**FFERM WYNT ALLTRAETH AWEL Y MÔR ARFAETHEDIG / PROPOSED AWEL Y MOR  
OFFSHORE WINDFARM**

**CYFEIRNOD YR AROLYGIAETH GYNLLUNIO / PLANNING INSPECTORATE REFERENCE:  
EN010112**

**RE: NATURAL RESOURCES WALES' WRITTEN SUBMISSION FOR DEADLINE 4**

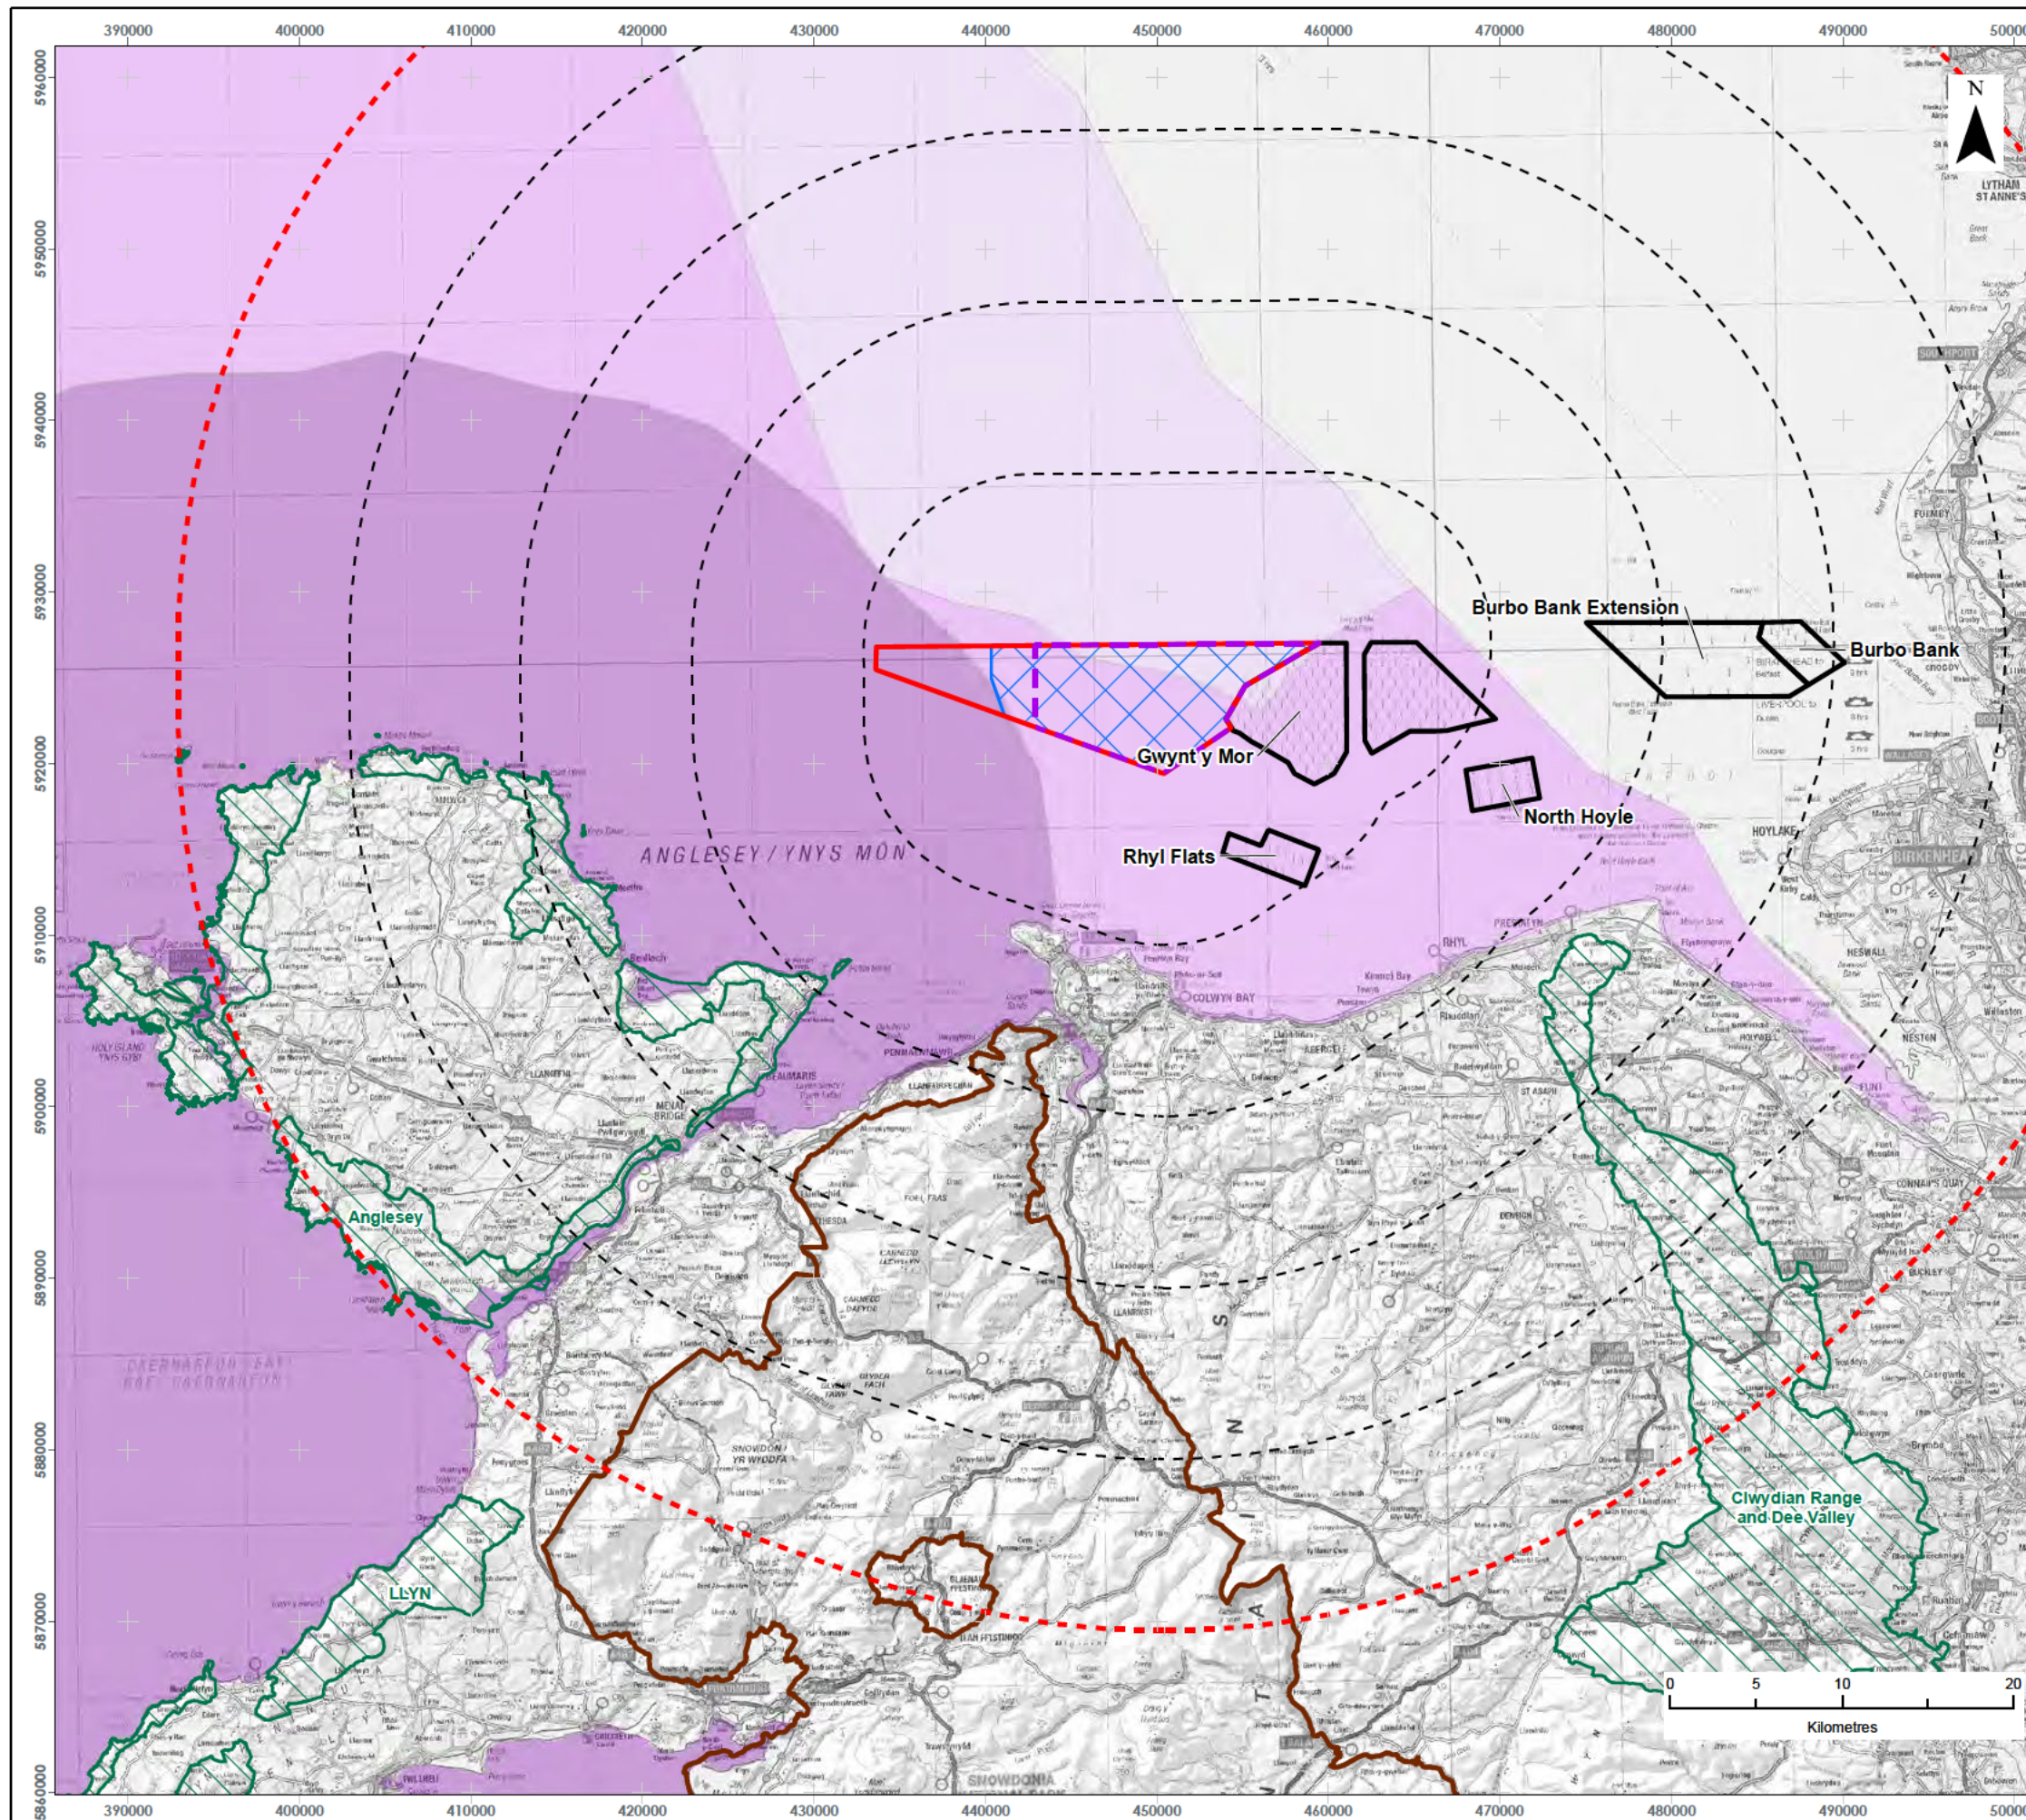
- 2.1.1. As detailed in our Written Representations at Deadline 1 [REP1-080], we advise a further substantial reduction in the array area and number of turbines, along with a reduction in scale and height of the turbines would be needed to minimise adverse effects on the Isle of Anglesey Area of Outstanding Natural Beauty (AONB) and Eryri (Snowdonia) National Park.
- 2.1.2. In paragraph 3.1.24 of REP1-080, we advised that further consideration be given to NRW's evidence base "*Seascape & visual sensitivity to offshore wind farms in Wales: Strategic*

NRW is not in a position to advise the Examining Authority with respect to the economic viability of the project and the extent of further reductions that may be economically/technically feasible. As explained in our REP1-080, in view of the nature and significance of the impacts and the Applicant's position with respect to any further reduction in scale, NRW consider that the proposal would represent a substantial degree of harm to the Isle of Anglesey AONB and Eryri (Snowdonia) NP which we consider would conflict with the purpose of these designated landscapes.
